CITY OF ALBUQUERQUE

July 22, 2025

Re: 7-Brews Coffee
3835 Coors Blvd. NW
30-Day Temporary Certificate of Occupancy
Transportation Development Final Inspection
Architect's Stamp dated 02-12-24 (G11-D067C)
Certification dated 07-07-2025

SITE PLAN  
SCALE: 1"=20'-0"

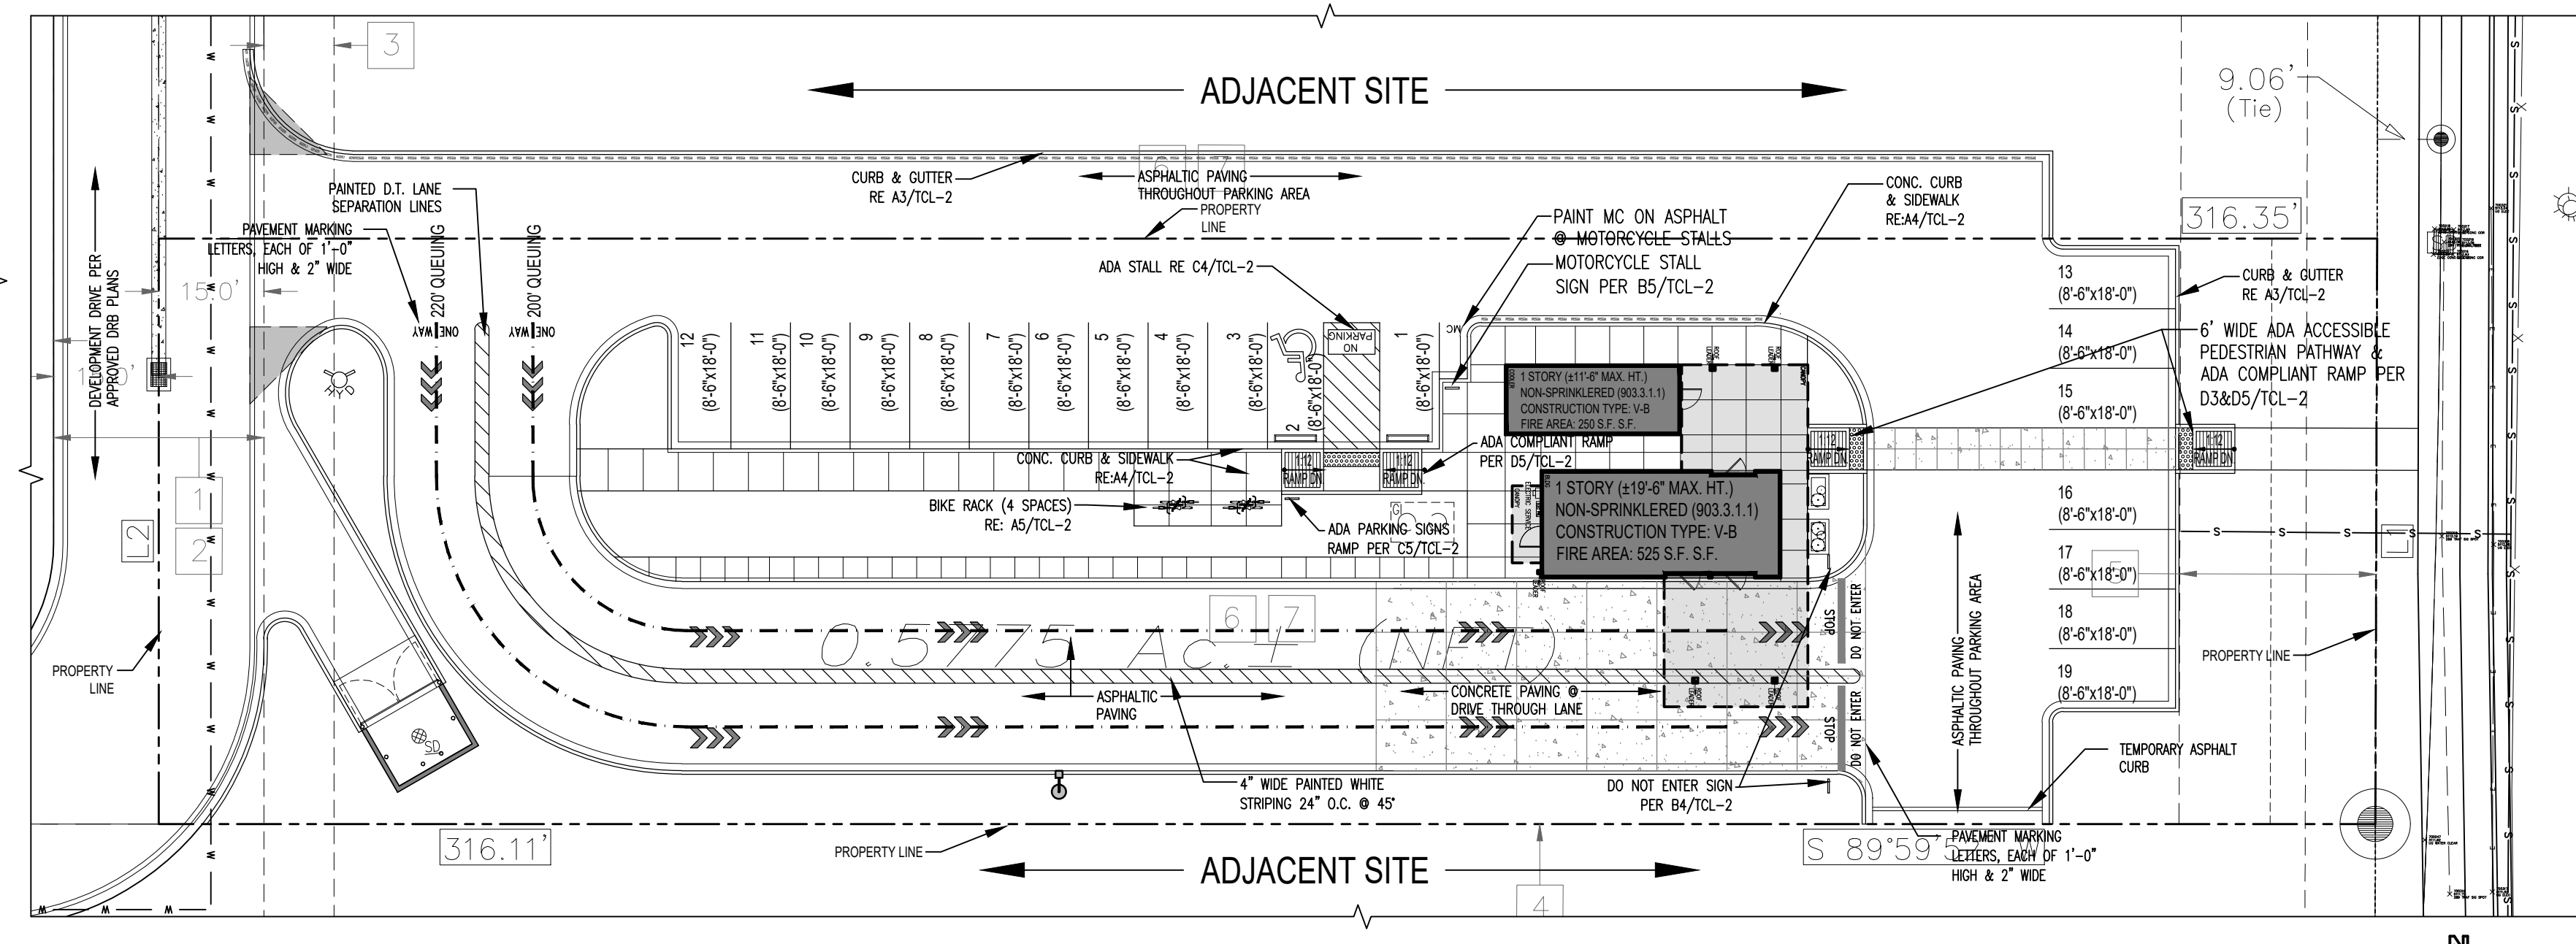
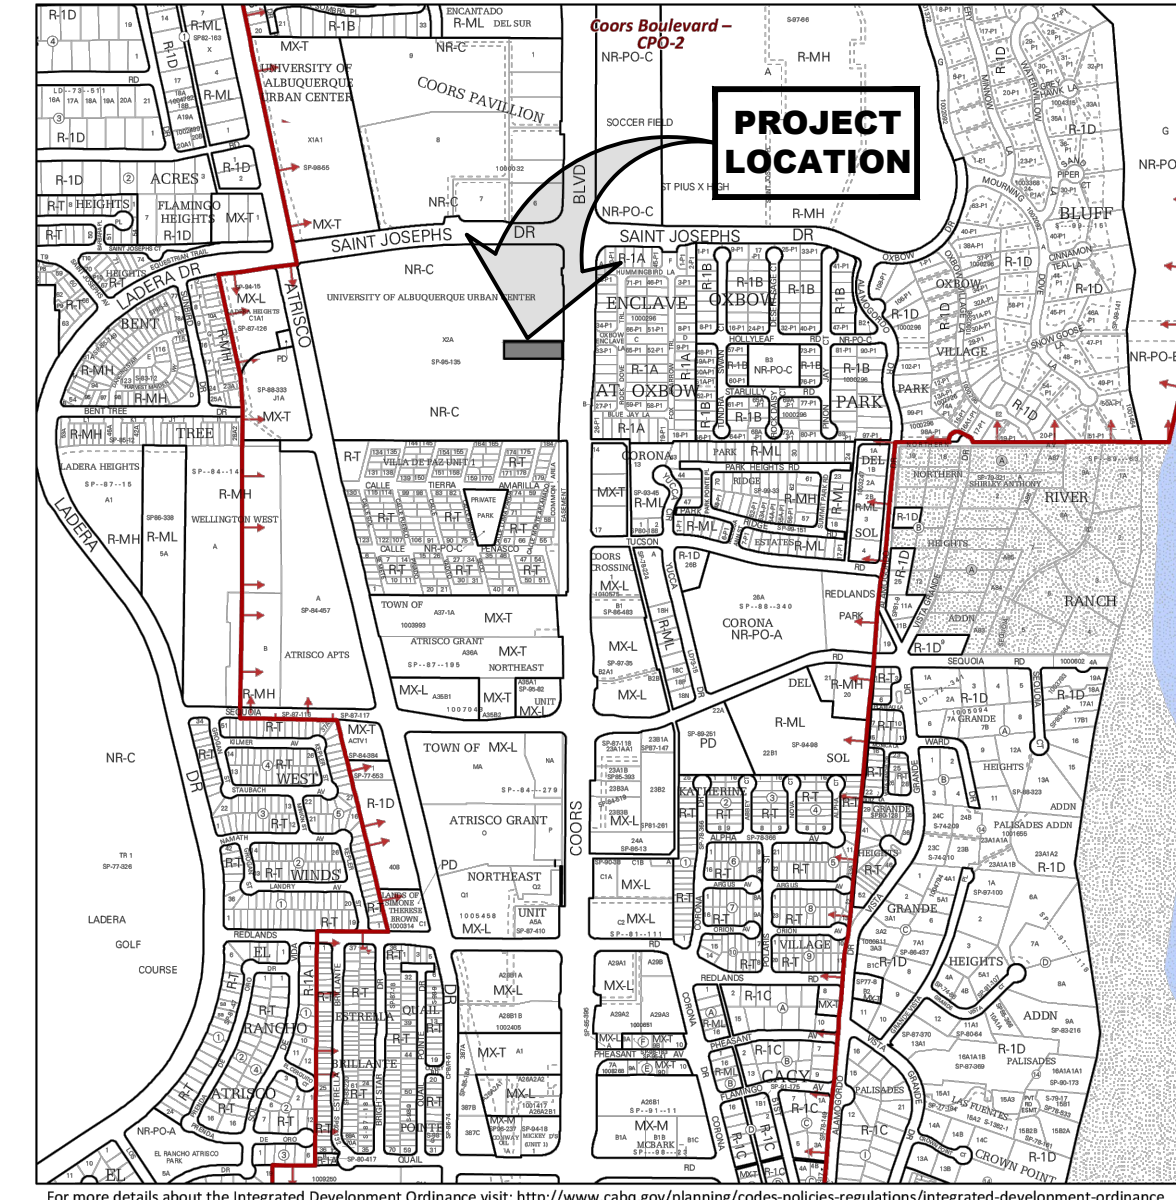
1. Please complete the construction of the accessible pathway.

2. Per city requirements and the approved site plan the ADA parking space should be 8.6 ft wide. However, per the site visit the measured width was only 8 ft. Please revise to meet the minimum required width of 8.5 ft per city regulations.
